A38 Derby Junctions Scheme – Further Written Representation from intu Derby (Deadline 11)

This response provides further comments and insights on behalf of intu Derby regarding Highways England's (HE) DCO application for the A38 Derby Junctions scheme. This follows on from our previous written submissions and attendance at Hearings. At this juncture, we seek to specifically address the following question raised by The Examining Authority (ExA):

“Are there any further comments or outstanding concerns regarding the Traffic Management Plan [REP7-003]? How should any outstanding concerns be addressed?”

Figure 3.2: Construction phases and TM scenarios

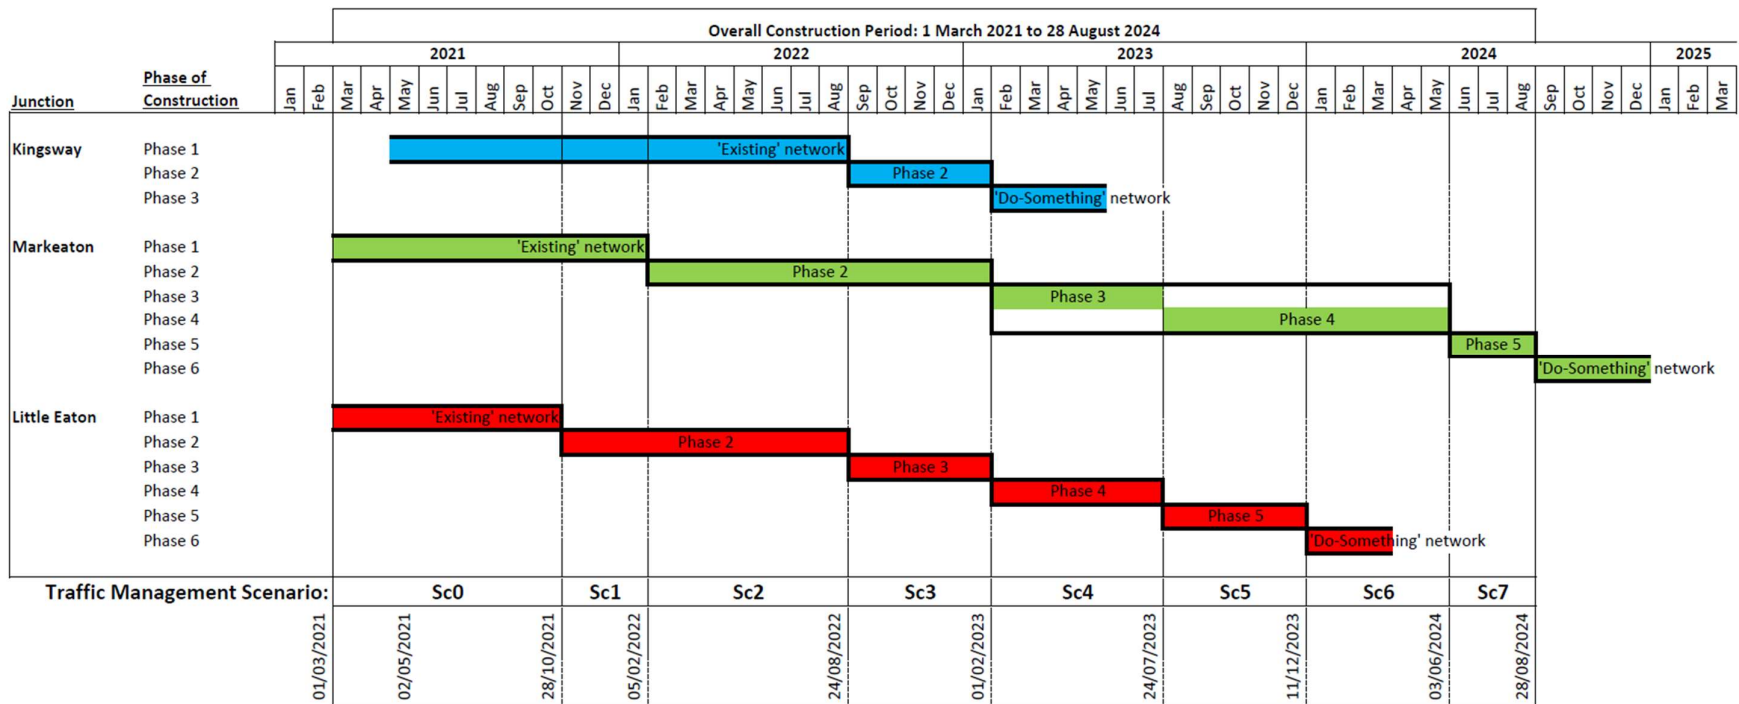
- **Congestion hotspots during the construction period** – The TMP states further junction modelling will be undertaken during construction preparation (Stage 5). This modelling needs to be undertaken at the earliest instance so that problem areas can be identified with sufficient time to subsequently develop and implement suitable mitigation measures in advance of the works commencing.

- **Clarity of diversionary routes per phase** – Consideration must be given to the scale of impact on the local network plus appropriate mitigation measures for links/junctions which are likely to be used by re-routed traffic as well as those routes directly affected by the construction works. From the technical drawings presented at previous BCWG meetings and being able to compare these to graphical output provided to intu by other roadwork schemes, we strongly encourage the HE seek to produce a series of clear and concise diversionary diagrams to illustrate the traffic restrictions during each phase of the works.

- **Contingency** – It is still not clear from the TMP exactly what level of contingency, if any, has been considered for the programme. Clarity on this matter would be welcomed – as noted before, our experience from other major road schemes has shown this element tends to be under-estimated and just one significant, unexpected issue can easily consume all/any planned contingency, leading to programme overrun and negative media coverage.
